Ribble Valley Borough Council
Development Control
Council Offices Church Walk
Clitheroe
Lancashire
BB7 2RA

Our ref: NO/2021/113709/02-L02
Your ref: 3/2021/0661
Date: 12 August 2022

Marl Hill Section. From land northwest of New Laithe Farm off the B6478 Slaidburn Road; and land north of Cross Lane, near Sandy Ford Brook, off the B6478 Slaidburn Road; with highway mitigation works at various locations from Pimlico Link Road, Clitheroe to Slaidburn Road, north of Waddington, via Chatburn Road, Ribble Lane and Grindleton Road; a haul route from land south of West Bradford Bridge to West Bradford Road, west of Healings Farm, West Bradford; a vehicle marshalling facility on land at the Ribblesdale Cement Works, West Bradford Road, Clitheroe and a park and ride facility at the existing Ribblesdale Cement Works car park west of West Bradford Road. Proposed works for and use of replacement section of aqueduct, including earthworks and ancillary infrastructure including: new valve house buildings within fenced compounds with permanent vehicular access provision. With the installation of tunnel shafts; open cut connection areas at either end of the replacement section within temporary const

SCALE 1: 2,500	SHEET SIZE A3
DRAWING NUMBER RVBC-MH-APP-004-05_04	REVISION 1

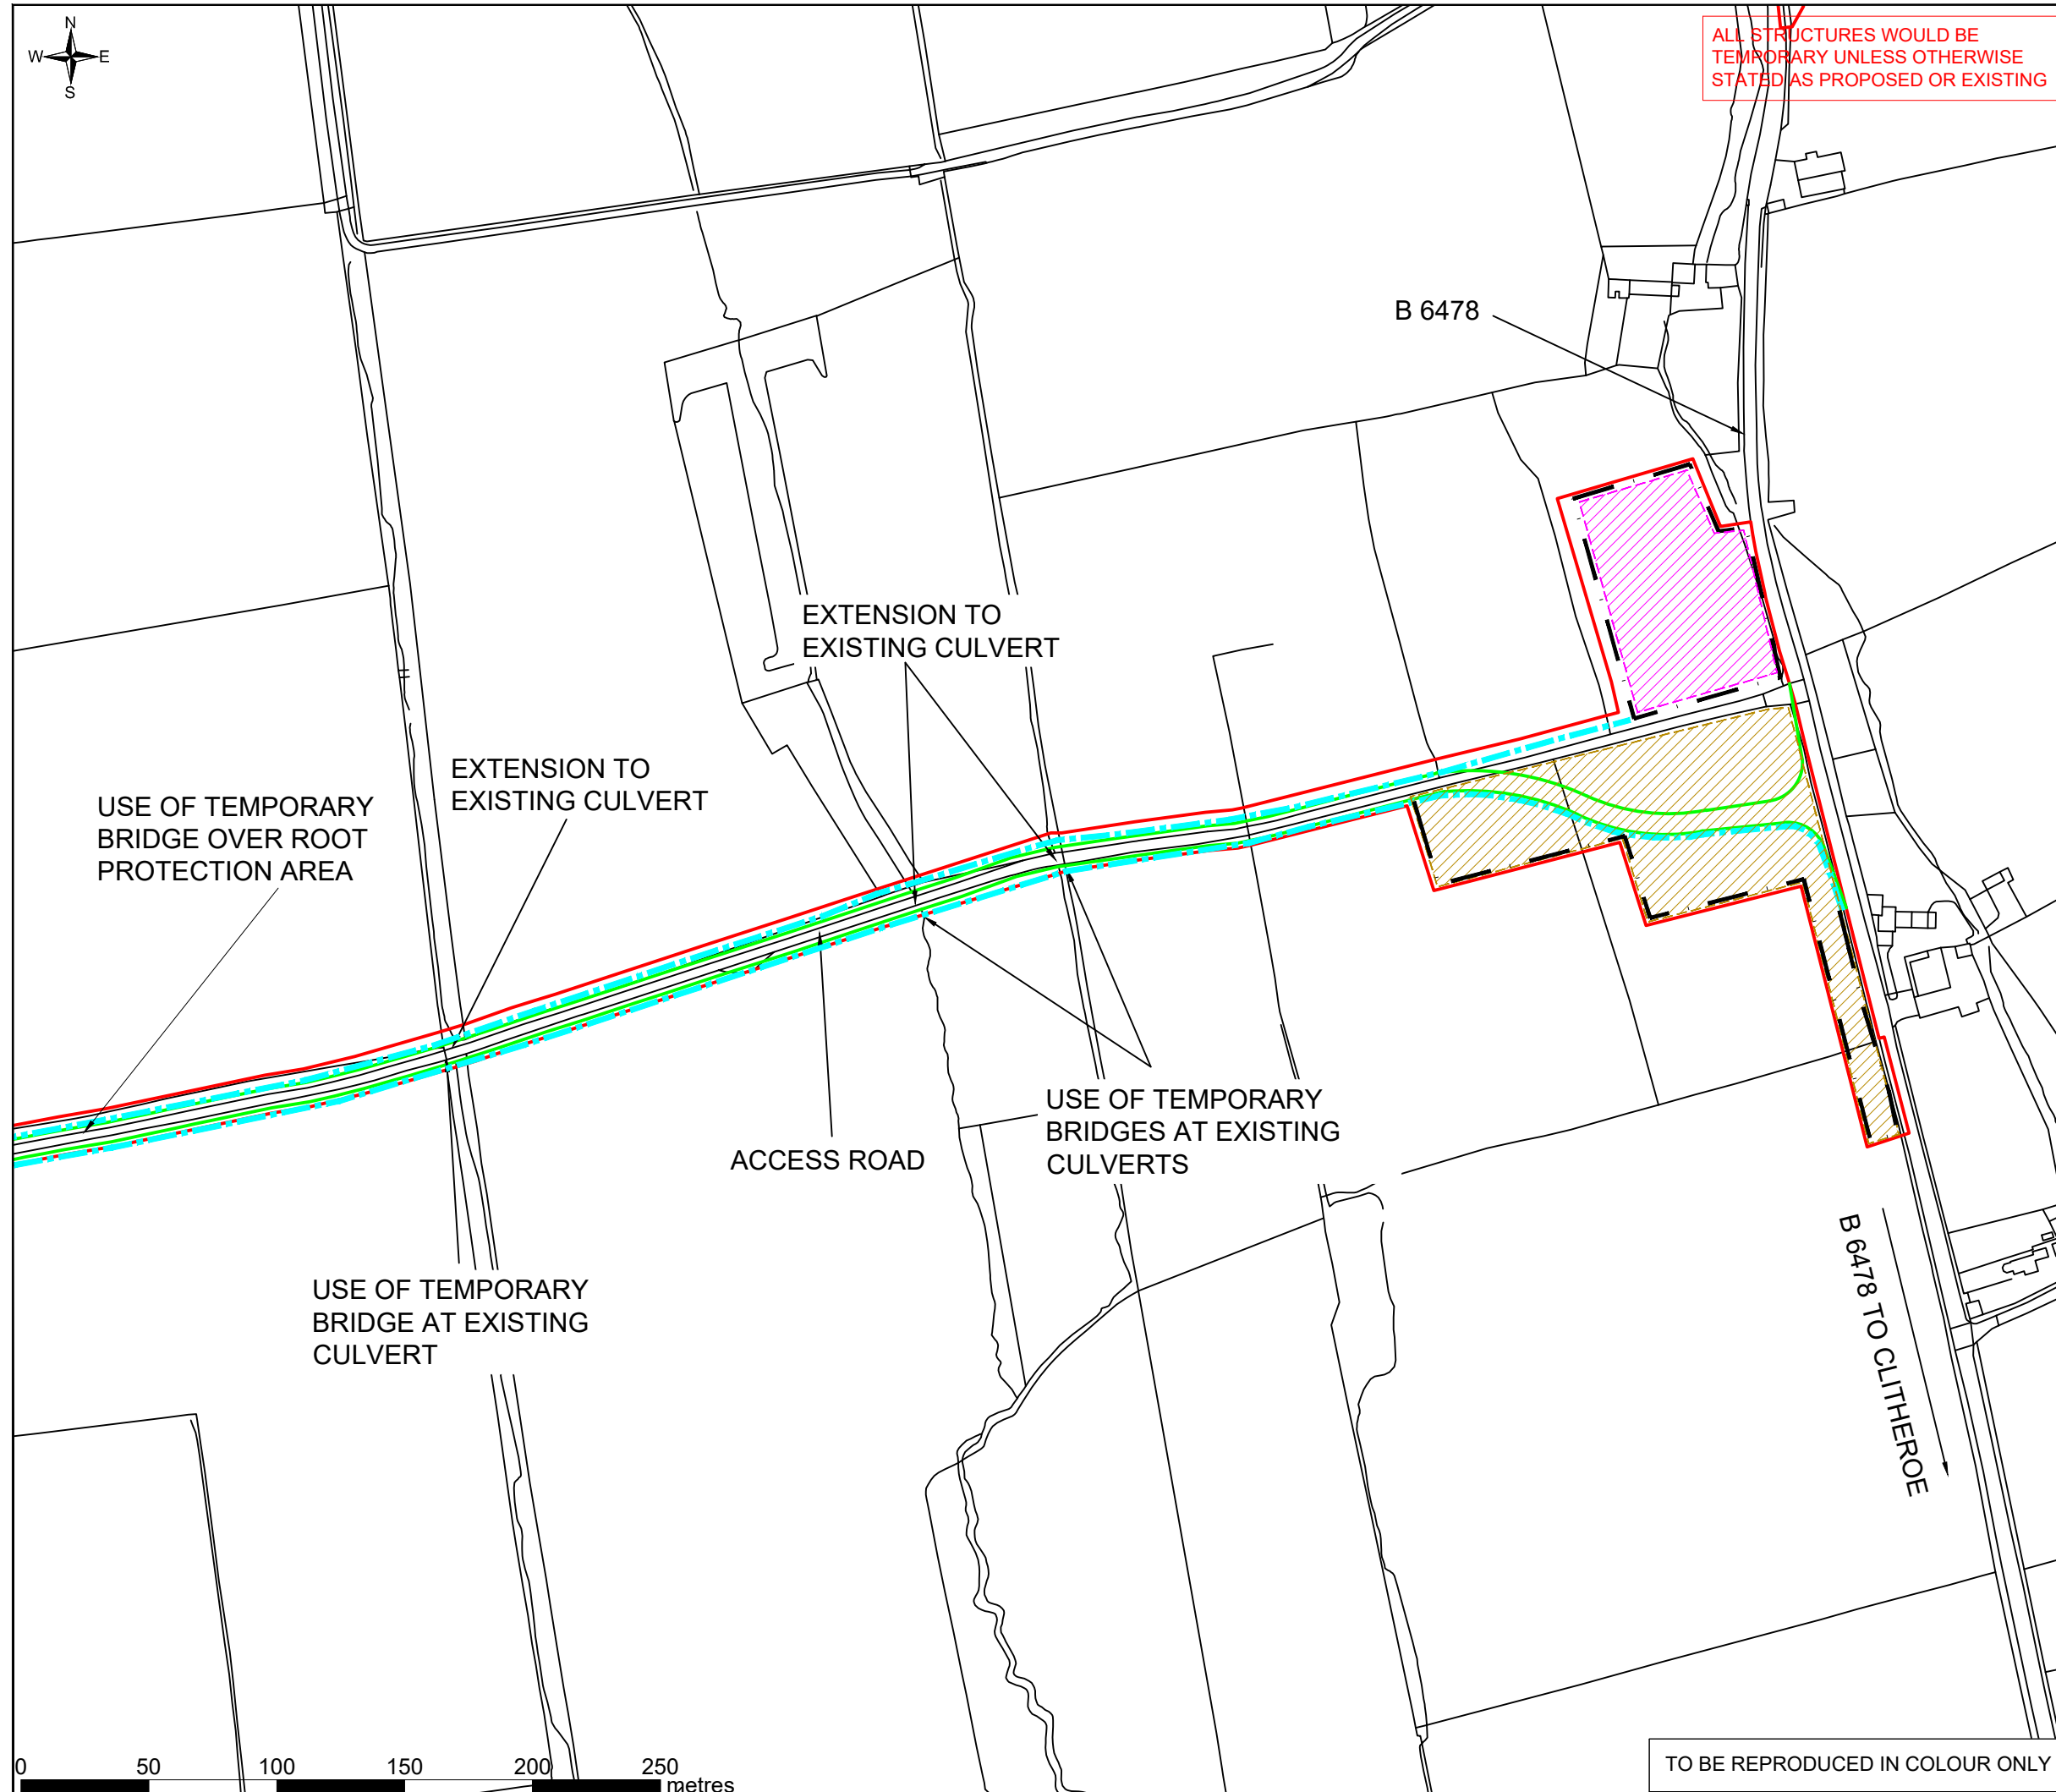
At Braddup compound a new culvert is proposed and existing culverts are to be extended along the access road. The applicant should clarify if these features are temporary (with the watercourses sections restored following the works), or if they are proposed as permanent culverts. If they are temporary, the method of the channel restoration should be provided, including restoration of bankside and in-channel habitats.

Elevated flow rates into the receiving watercourse from the Braddup compound have the potential to cause scour and erosion that could damage existing bankside and in-channel habitat within the receiving watercourses. More detail will be required to demonstrate how these flows will be attenuated using the drainage ponds to establish a sustainable flow rate for the receiving watercourses that does not cause these adverse impacts. A drainage plan should be developed to ensure discharges from the proposed works do not exceed this level.

PLAN VIEW
(SCALE 1:1000)

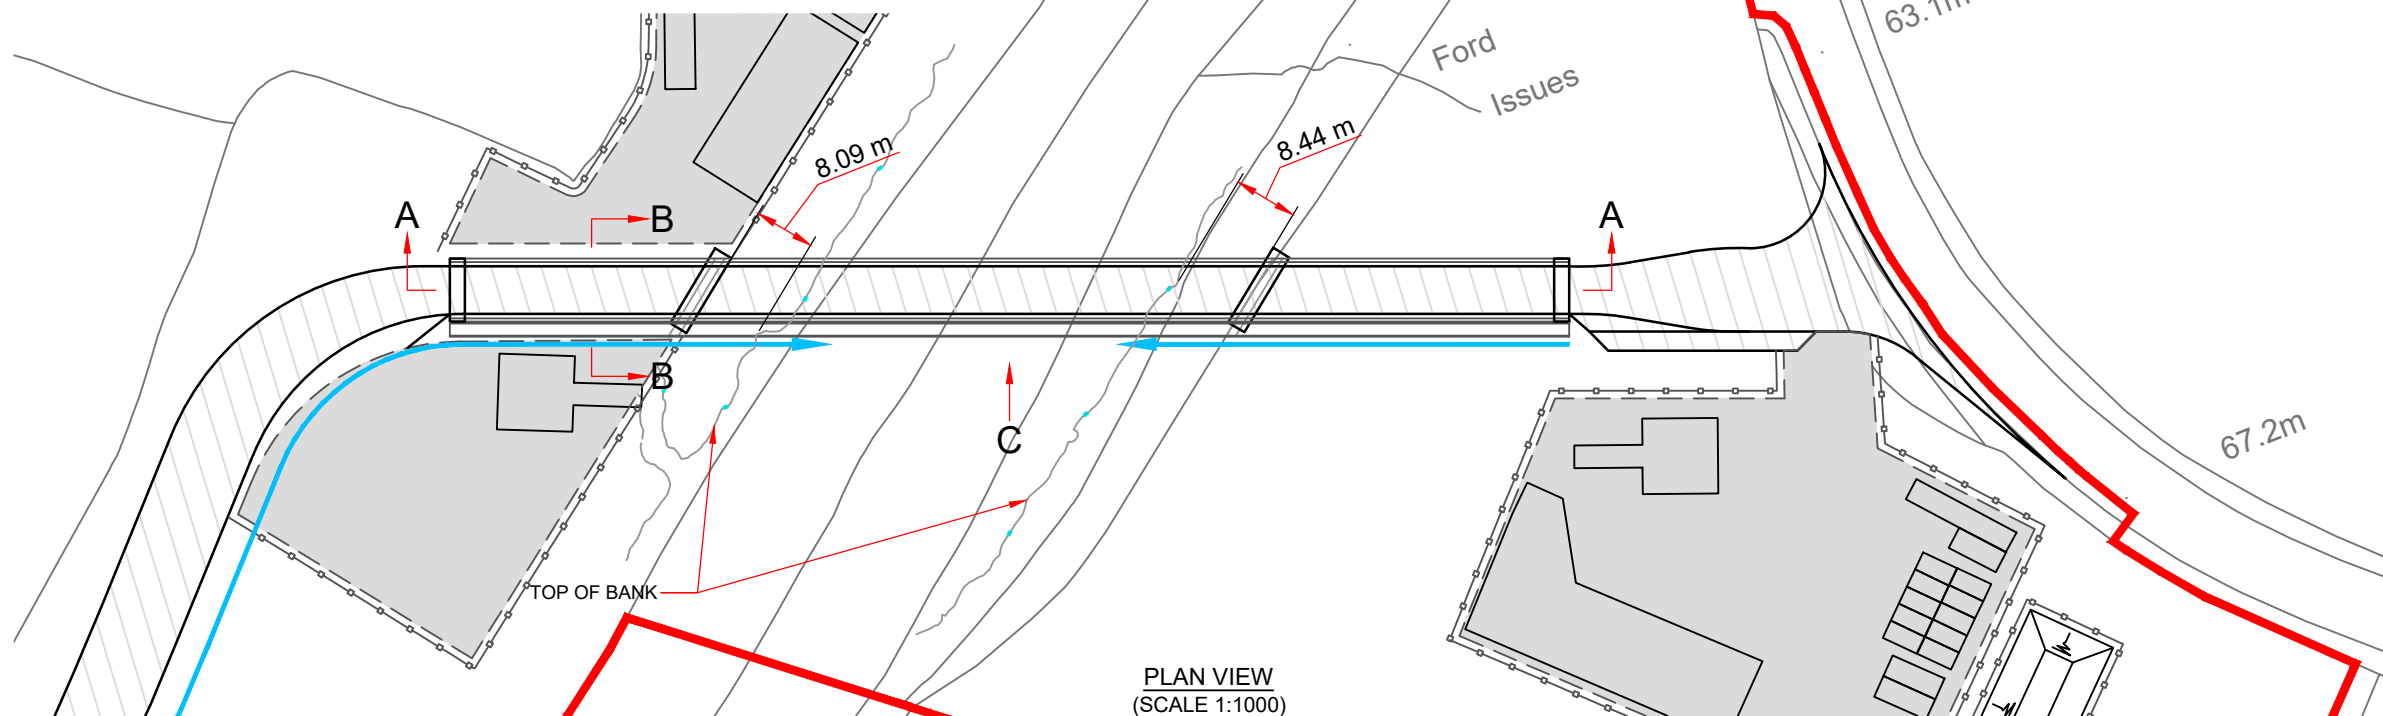
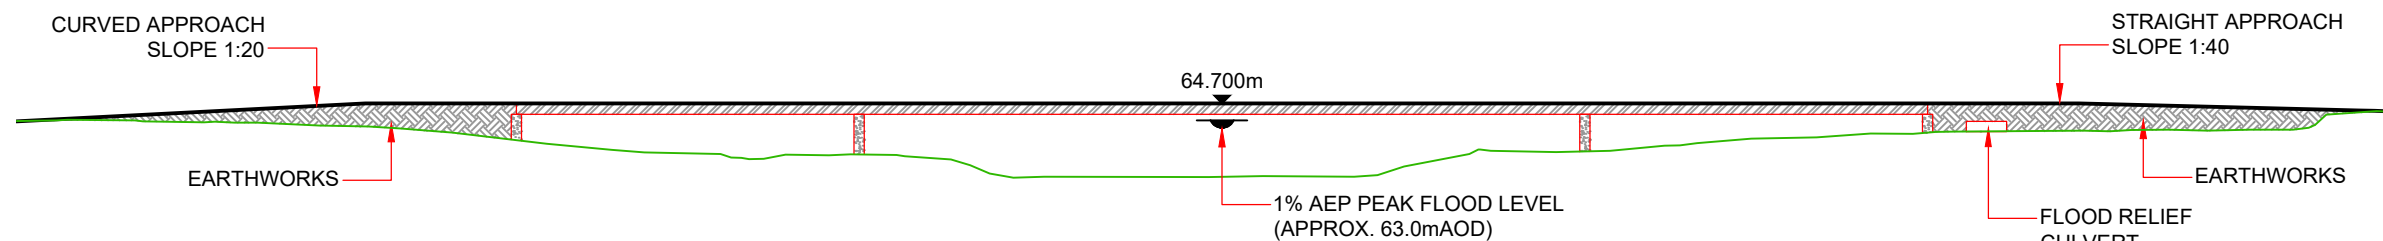
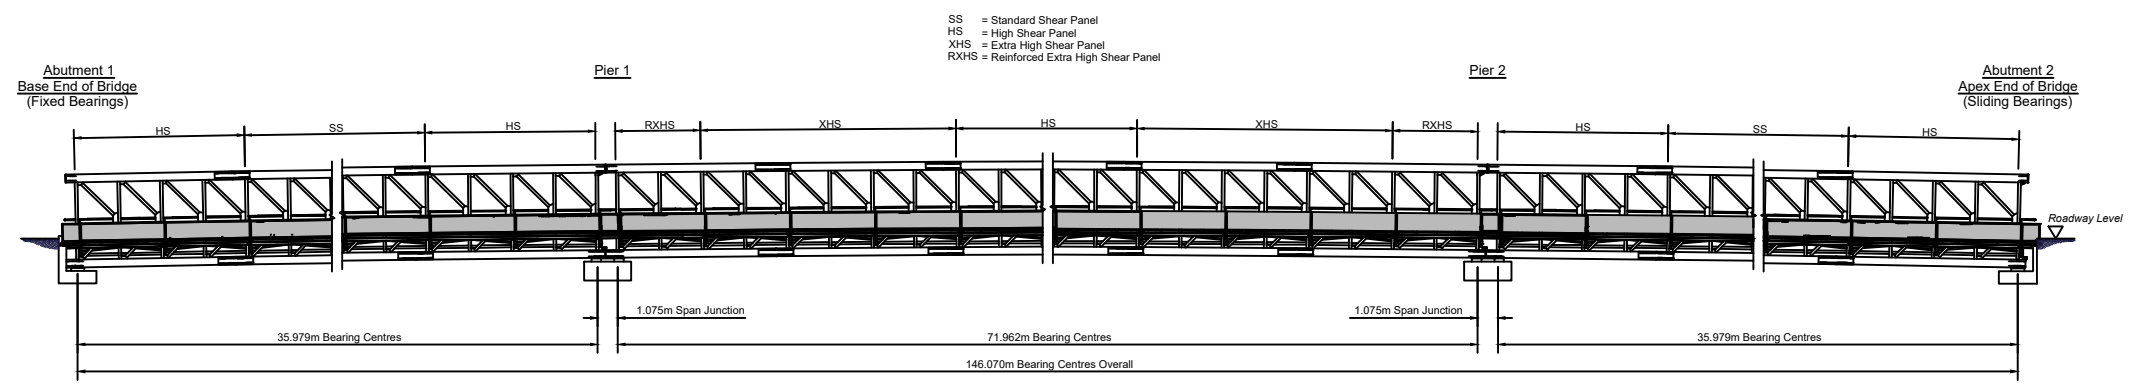
The principle of an open span bridge to carry the haul road across the River Ribble has been established in the submitted plans. The drawings show the bridge abutments set outside of the flood extent with two piers placed closer to the channel, set parallel to the flow. These design principles have particular significance as the crossing near West Bradford has the potential to cause significant disturbance/damage to bank side and in-channel habitats, affecting fish, otter and geomorphological processes on this section of the River Ribble. The use of an open span bridge is welcomed but the proposed works,

which also includes surface water outfalls to the Ribble, still pose a significant risk to the river habitat at this point. This location has high fisheries value providing salmonid and eel migratory routes and habitat for sea trout, brown trout, bullhead and lamprey.

The impact of silt discharge to the River Ribble of proposed surface water runoff from the haul road via outfalls should be considered as locally significant from these proposed works. It is currently unclear exactly how adverse impacts will be prevented/minimised. Currently the application relies on generic mitigation embedded into the wider scheme Construction Code of Practice. Once the detailed designs have been finalised, the applicant will be required to apply for a Flood Risk Activity Permit from the EA for the outfalls and other works adjacent to the river, at this stage the applicant must provide more specific detail regarding the proposed mitigation. The proposed mitigation should address the key risks of habitat damage, disturbance and silt pollution at this location, for example through the use of siltbuster, settlement ponds and treatment of runoff prior to discharge. The permit application should outline the actual mitigation measures proposed to avoid these adverse effects.
